Marine Management Organisation

MMO Reference: DCO/2019/00004
Planning Inspectorate Reference: EN010109

Planning Act 2008, Proposed Sheringham Shoal Offshore Wind Farm Extension Project (SEP) and Dudgeon Offshore Wind Farm Extension Project (DEP).

Deadline 2 Submission

Figure 1: SEP and DEP Proposed Disposal Site Locations

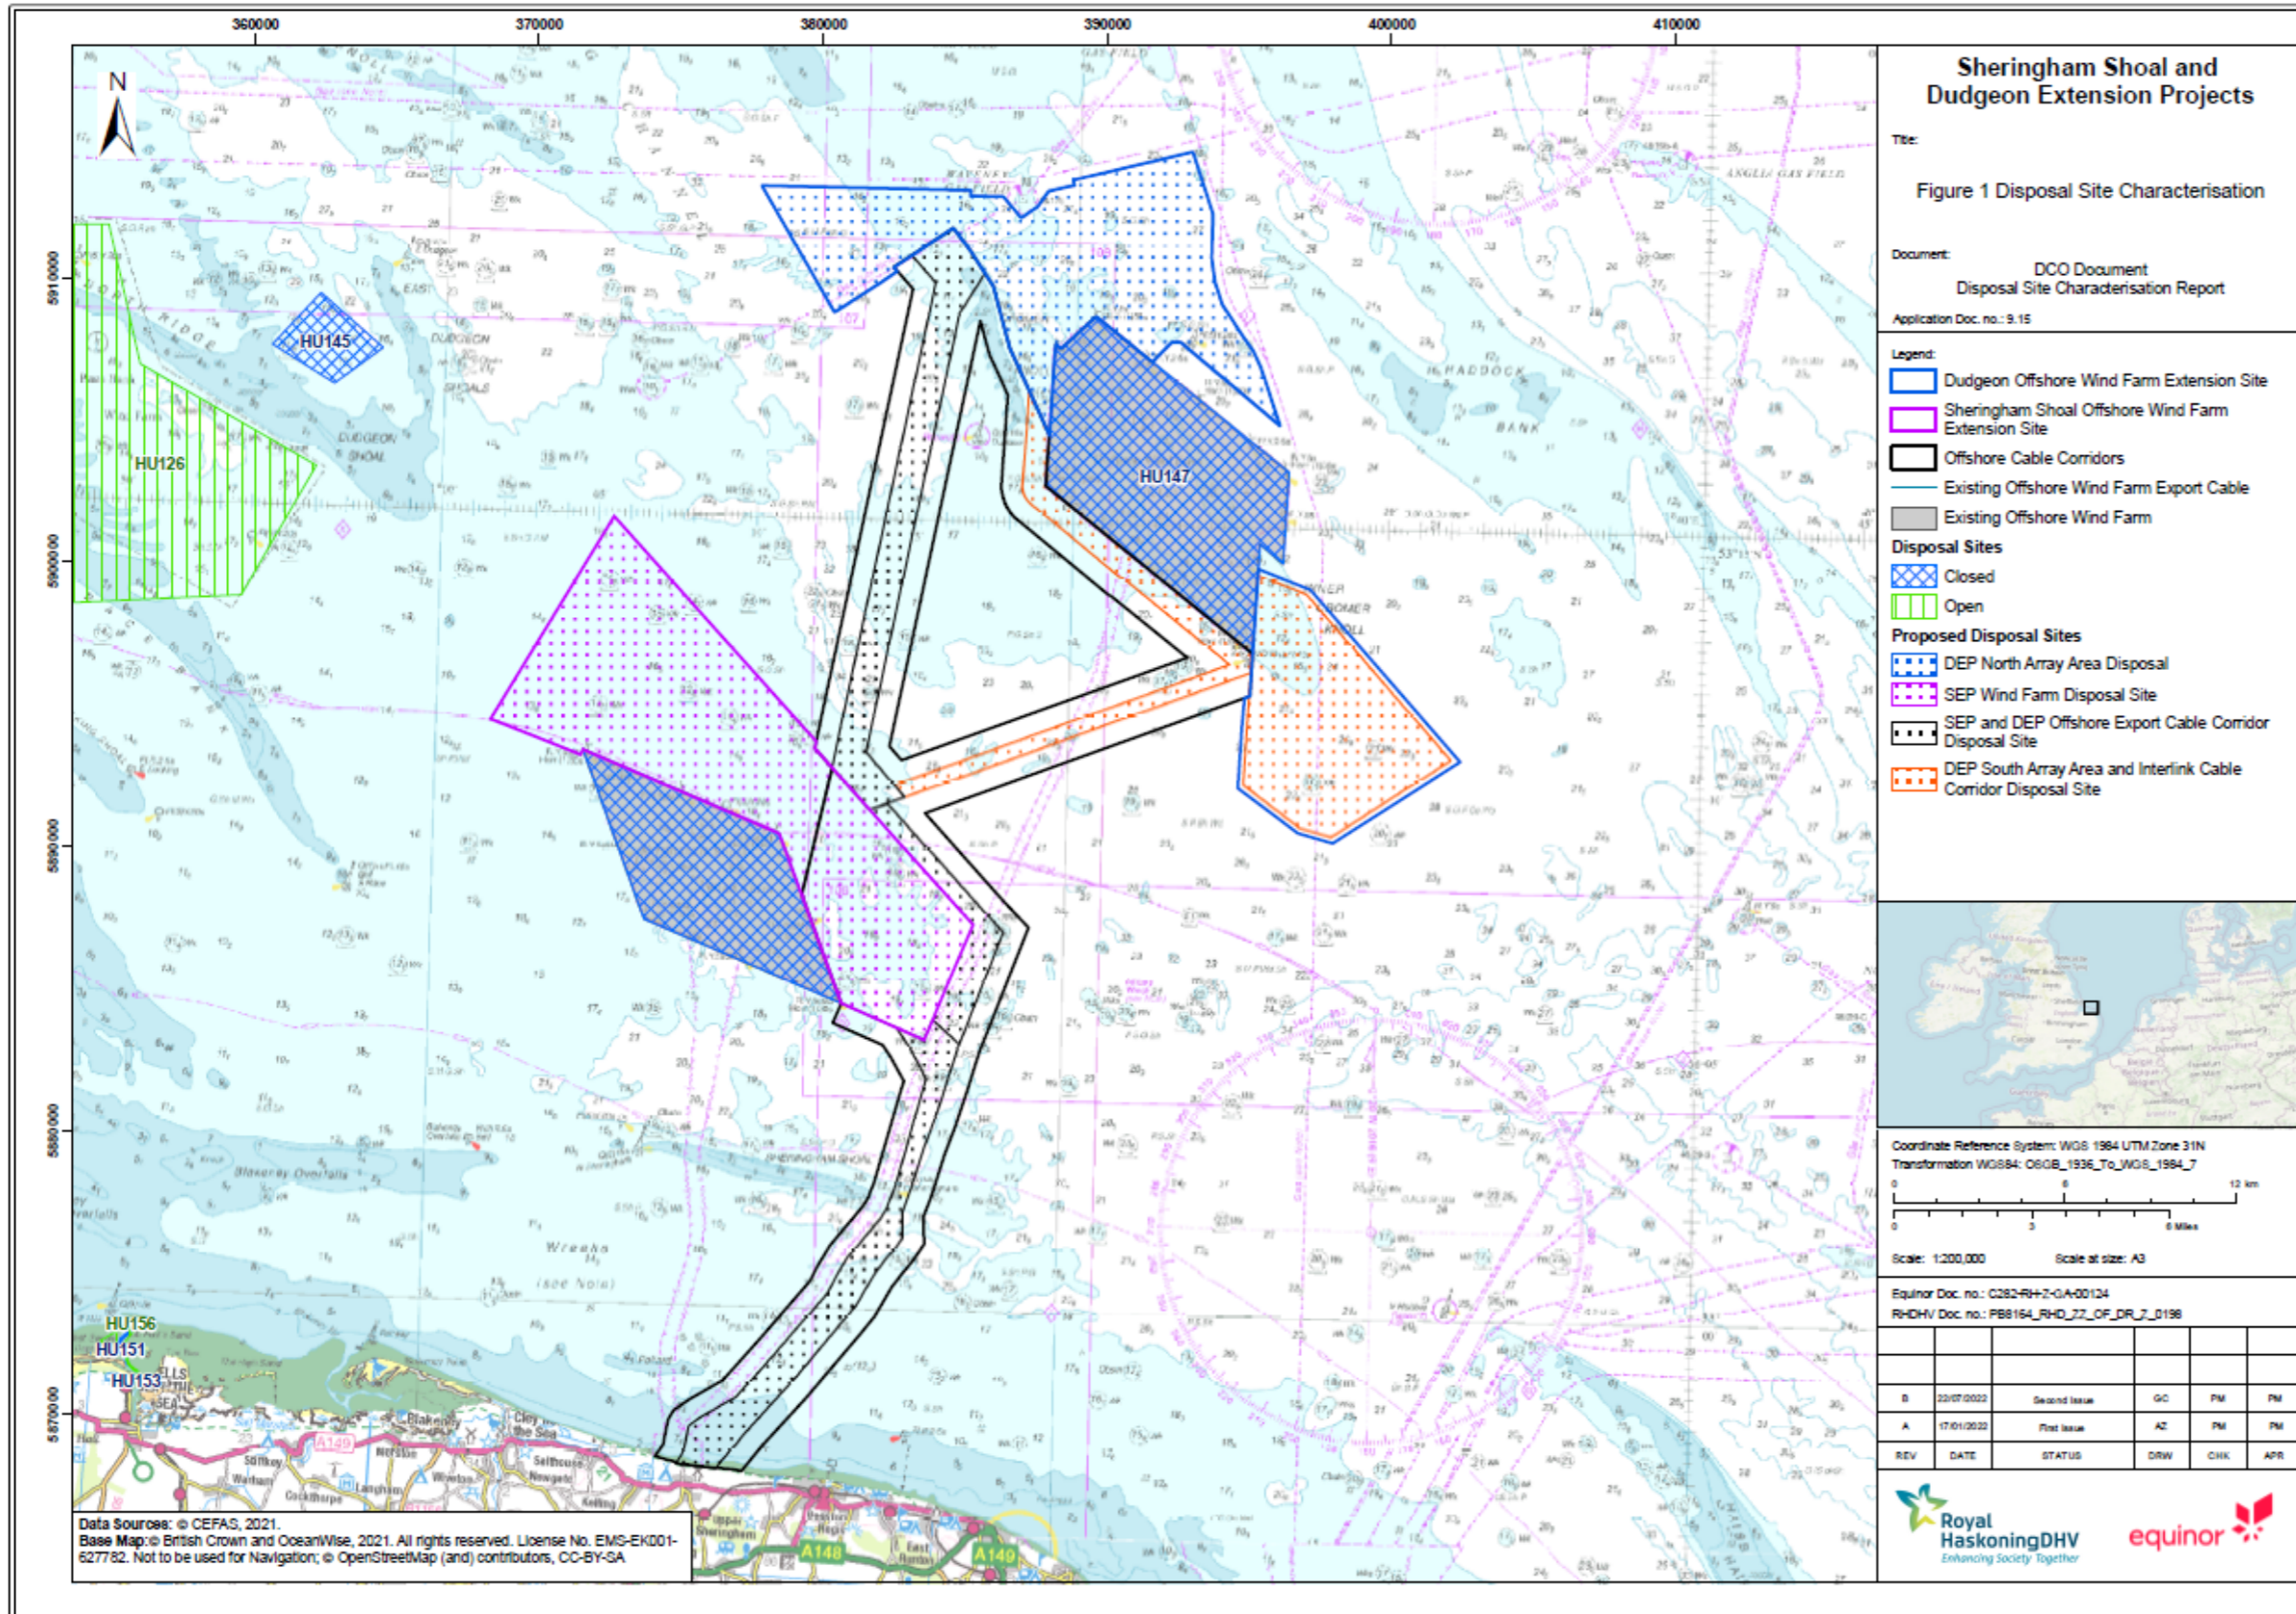
- 5.2 The MMO note that fish receptors have not been referenced anywhere within the Disposal Site Characterisation Report (DSCR), and therefore the potential impacts relating to fish receptors has not identified or assessed. Whilst there is signposting to relevant sections of the Environmental Statement (ES) in relation to the potential impacts of disposal, these refer to physical processes, marine water and sediment quality, and benthic ecology only. The MMO would have expected to see a discussion on the impacts of disposal on fish receptors within the DSCR, or signposting to the relevant sections of Chapter 9 (Fish and Shellfish Ecology) of the ES in which the impacts to fish have been assessed. This is of particular relevance to herring and sandeel as both species are reliant on specific sediment types for part or all of their life stages and could therefore be vulnerable to impacts from the disposal of dredged arisings, especially if this results in changes to sediment composition.

- 5.3 Although no reference has been made to fish receptors or their ecology, the MMO note that the Applicant has identified impacts relating to benthic ecology. The impact pathways identified by the Applicant for benthic ecology would also be relevant for fish receptors:

- 5.4 The most vulnerable fish receptors to disposal of dredged material are likely to be those with a strong association with the seabed, such as herring and sandeel. Herring require sediments with a high gravel content and a low proportion of fine sediment for spawning. Whereas sandeel show a strong preference for medium and coarser sandy sediments and avoid areas of fine sediment. Disposal of 1,131,319m³ of dredged arisings has the potential to change the sediment composition, which could reduce its suitability as herring spawning habitat and/or sandeel habitat. Although no net sediment transfer is planned between disposal areas, changes could occur within the disposal areas which contain both suitable and unsuitable sediment types. If sediment is released at the surface (the worst-case disposal method), this will form a plume, the size of which will depend on factors such as sediment type, particle size and currents. There is the potential for some particles, especially finer silt particles which are unsuitable for herring and sandeel, to travel some distance in the period of half of a tidal cycle (six hours). In addition, the sub-surface arisings produced during drilling activities are likely to be finer and may result in a net increase in finer sediment in each disposal area. However, it should be noted that the volume of sediment produced during drilling activities is relatively small, making up approximately 2% of the arisings for disposal (see Annex 1). In addition, it should be noted that the seabed in the area is considered to be relatively dynamic, with background SSC relatively high (10-30mg/l) and increasing further with winter storms.

- 5.5 The MMO note that the applicant has assumed 'worst-case' scenarios for the construction methods to determine the 'worst-case' disposal volumes and effects, which is appropriate. The scenarios include assuming the maximum amount of sand-wave levelling (SWL) required, the use of piled foundations requiring drilling, SEP and DEP being built concurrently, the maximum amount of wind turbine generator (WTG) and substations, and the assumption of dredged arisings being released from the surface as overflow from the dredger. Whilst I support the use of worst-case scenarios, it is my understanding that the Applicant may have overestimated the maximum amount of arisings produced. As a mitigation measure, the Applicant has committed to positioning monopile and jacket foundations for WTGs in such a way as to avoid the need for seabed preparation. However, when estimating the maximum sediment volume (1,131,319m³), this figure is derived from combining, among other things, seabed preparation (wind turbines) and drilling (wind turbines) which should be mutually exclusive (see Annex 1). This would result in a worst-case scenario of 1,107,427m³.

- 5.6 The MMO recommend that the Applicant uses a fall pipe in all disposal activities wherever practicable, to ensure that sediments are broadly returned to the same areas they were removed from. This may help to ensure that sediment composition will remain broadly the same in areas of herring spawning habitat and sandeel habitat.
